Markup Summary **Plat**

ENG-SF19004-R2-LOI-Redlines_Summary

ENG-SF19004-R2-FDR-Redlines_Summary

Markup Summary CDs

HOMESTEAD AT STERLING RANCH FIL. NO. 2			
SAND FILTER PONDS LOTS 13-24			
PROJECT NO. 09-007	FILE: Yang\Const.Dwg\Street & Storm Plans\ST11.dwg	DATE: 11/19/2019	SHEET 11 OF 14 ST11
DESIGNED BY: CMM	SCALE: 1"=10'	VERT: N/A	
DRAWN BY: CMM	CHECKED BY: VAS

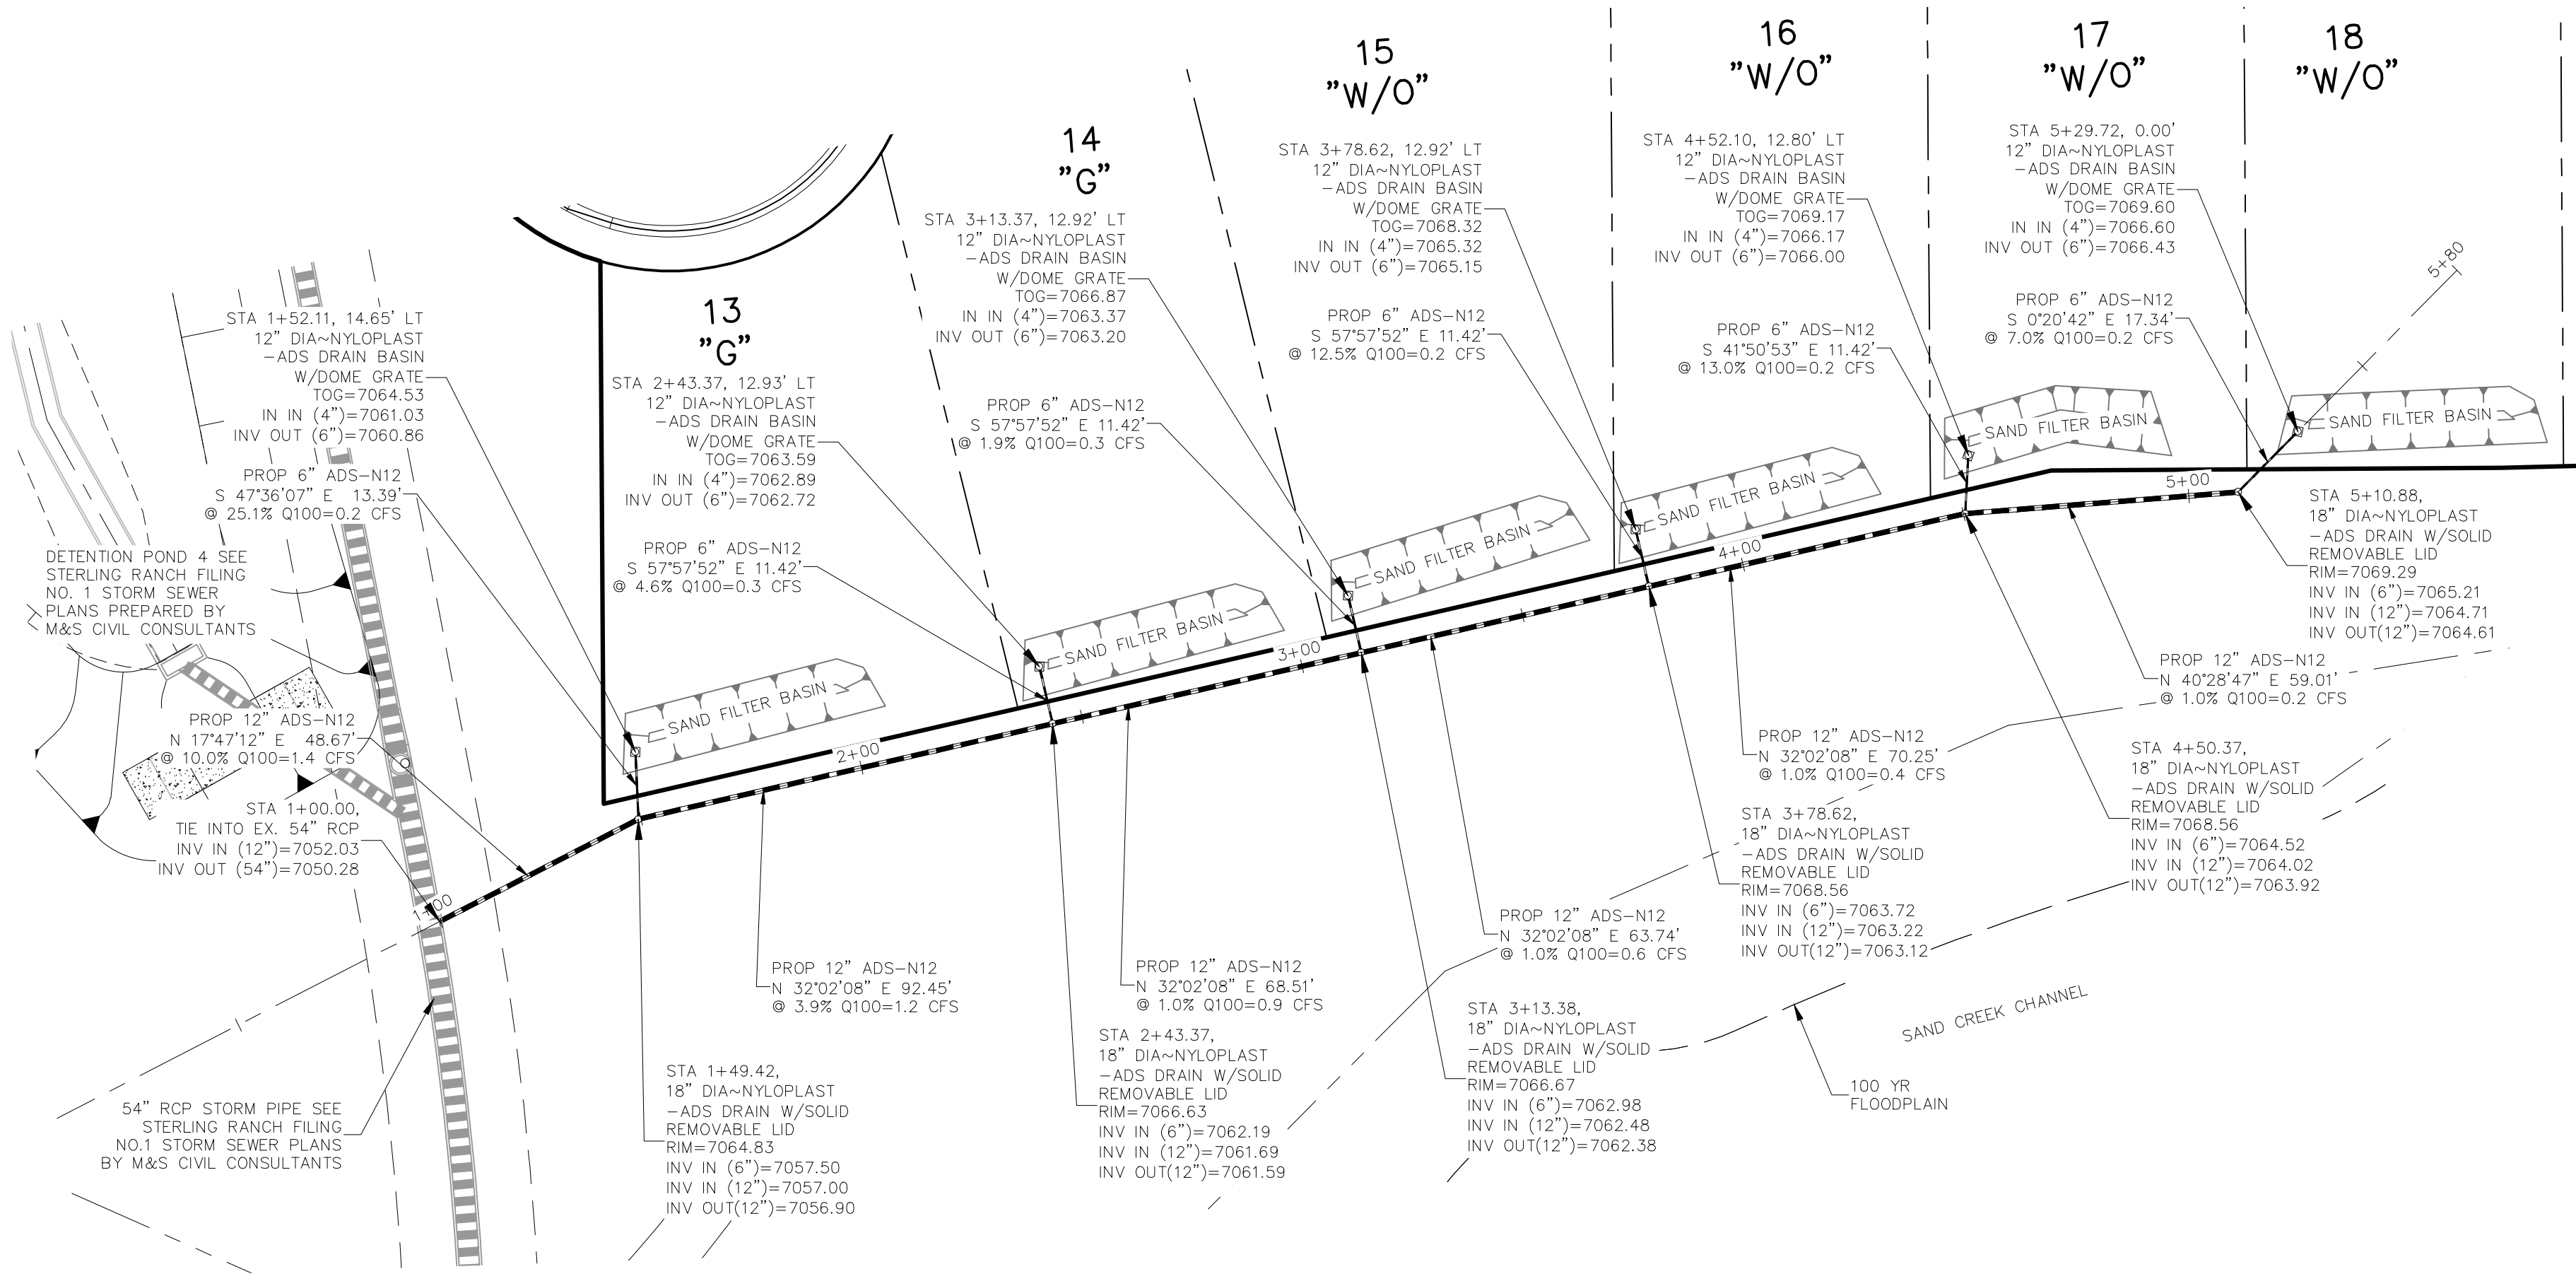
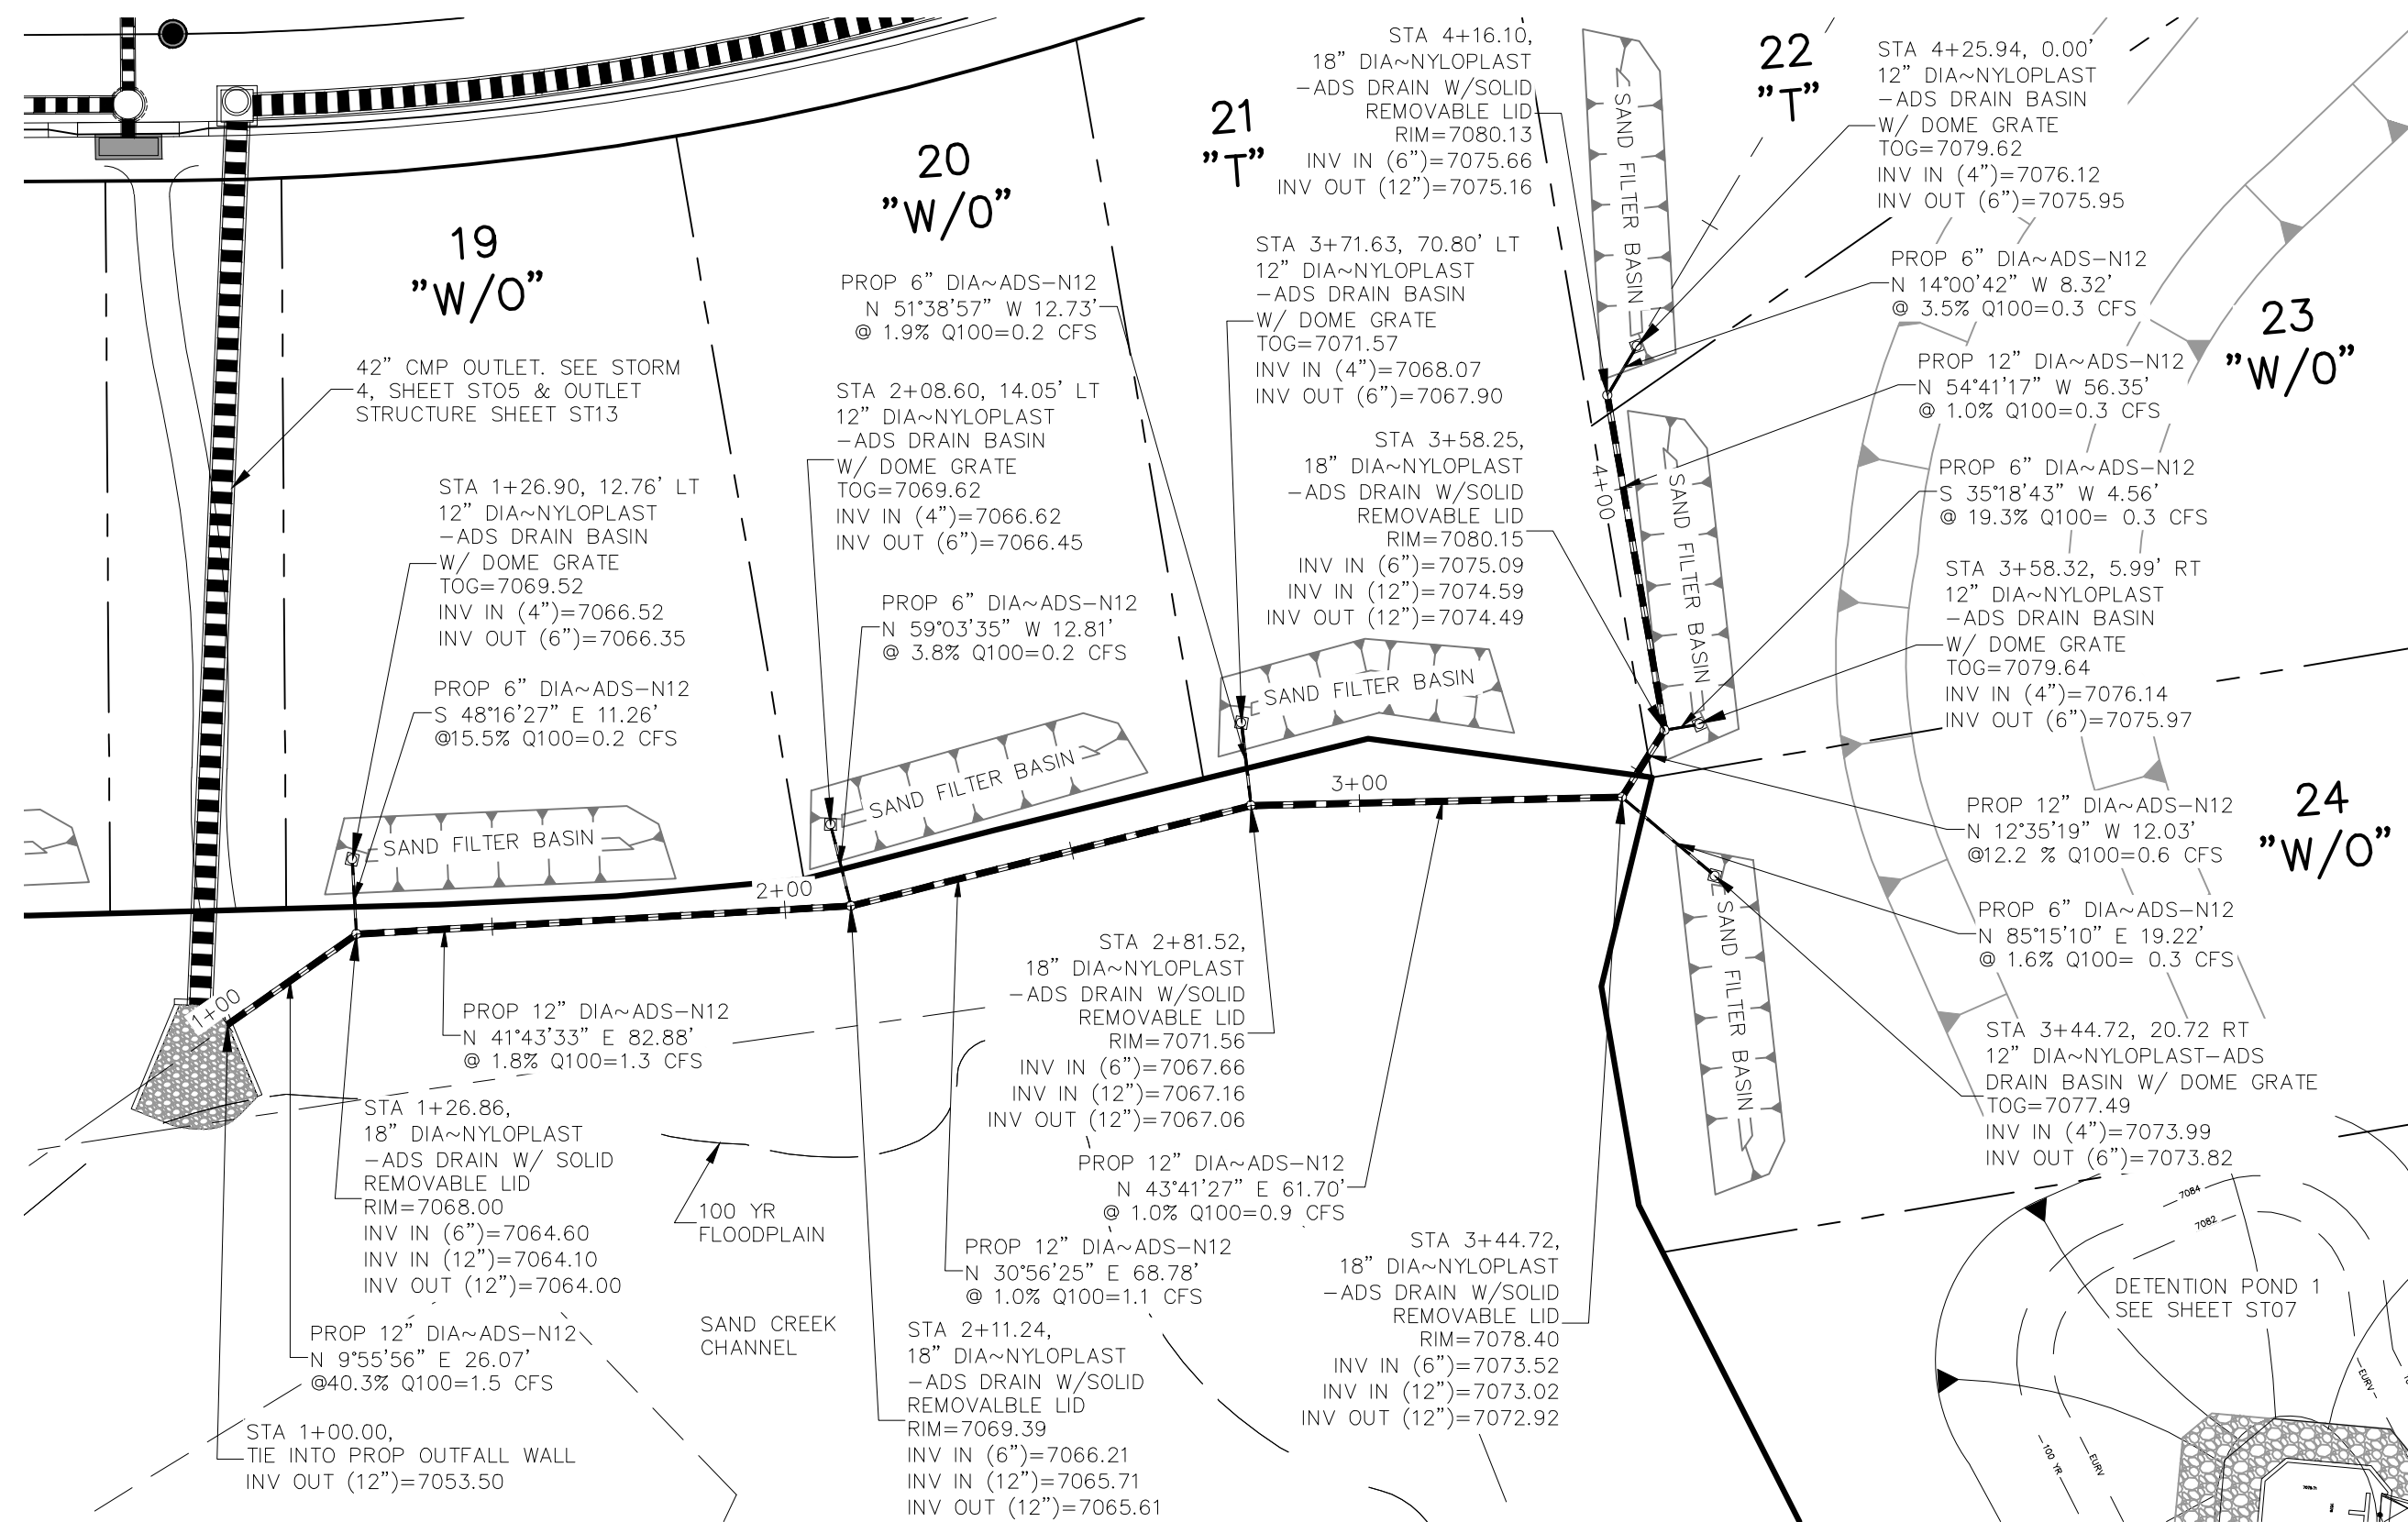
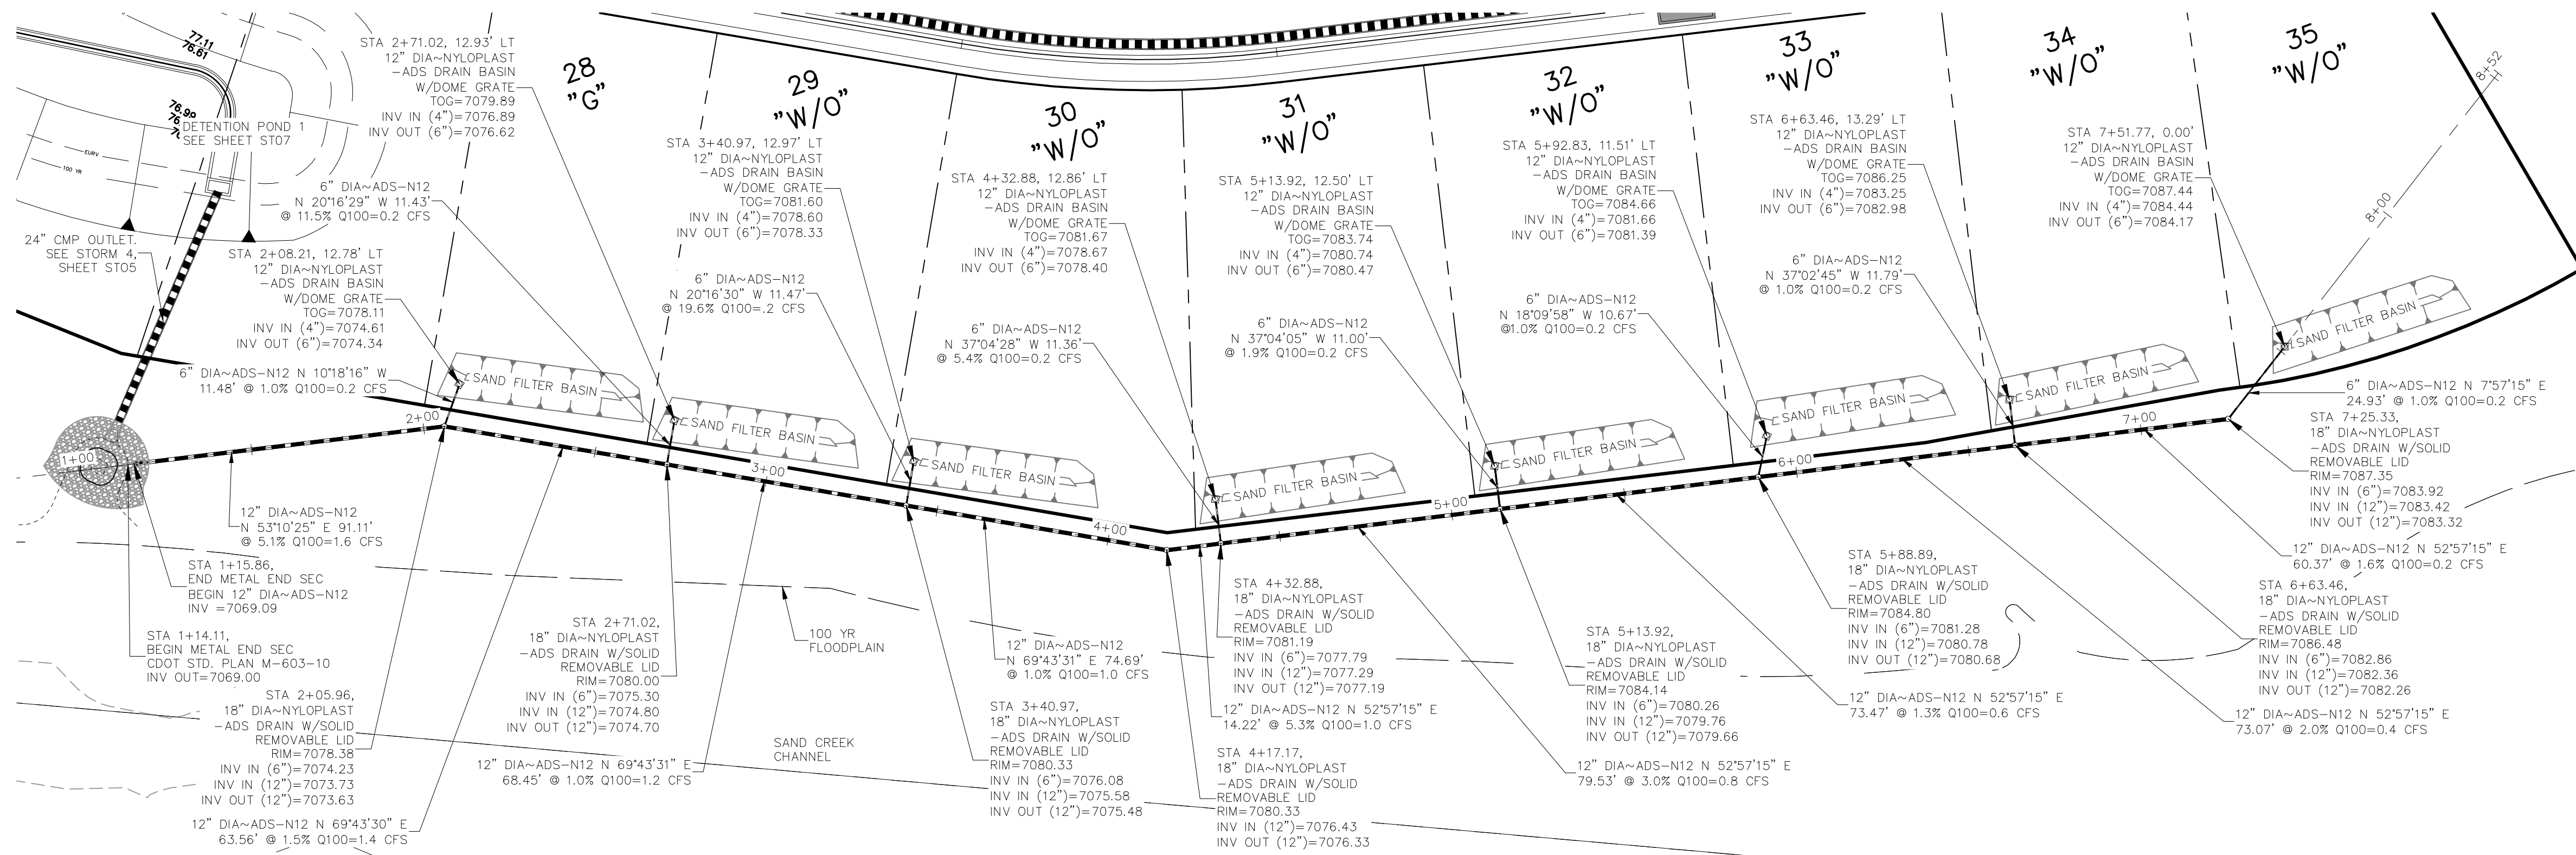
It appears that more stabilization (or spreading mechanism) is needed to the channel bottom.

Clearly show and label the proposed trail through the site.

Will the trail be utilized to access and maintain the SFBs?

provide maintenance access roads
